Town & Country Planning Act 1990 (as amended)
Town and Country Planning (Development Management Procedure) (England) Order 2015
Application for Planning Permission

Development Single storey front extension
Location 8 Osborne Way Bognor Regis West Sussex

8 Osbourne Way

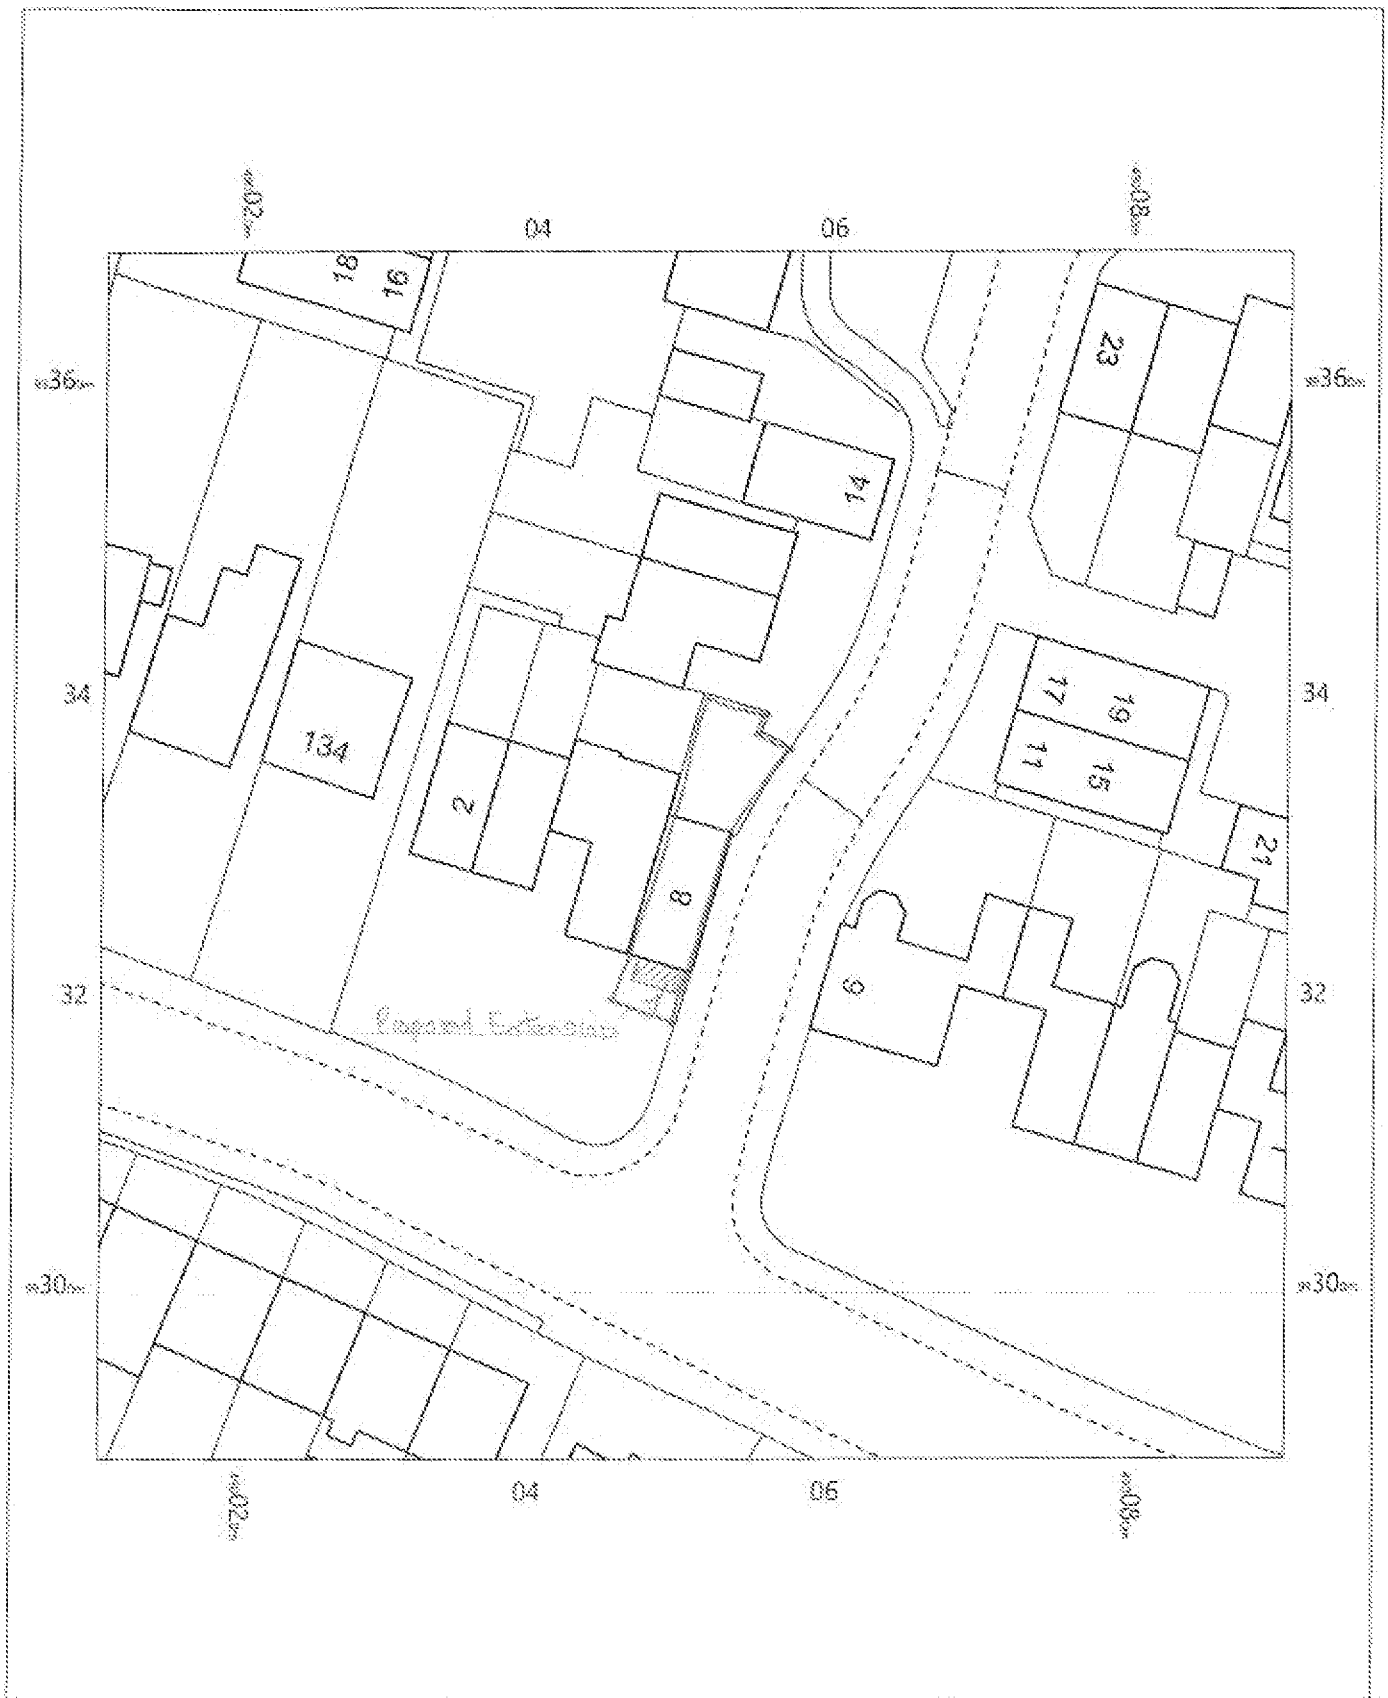
Block Plan

Please submit 1 electronic or 3 paper copies of an amended block/site plan at a scale of 1:500 or 1:200 showing the measurements to the boundaries
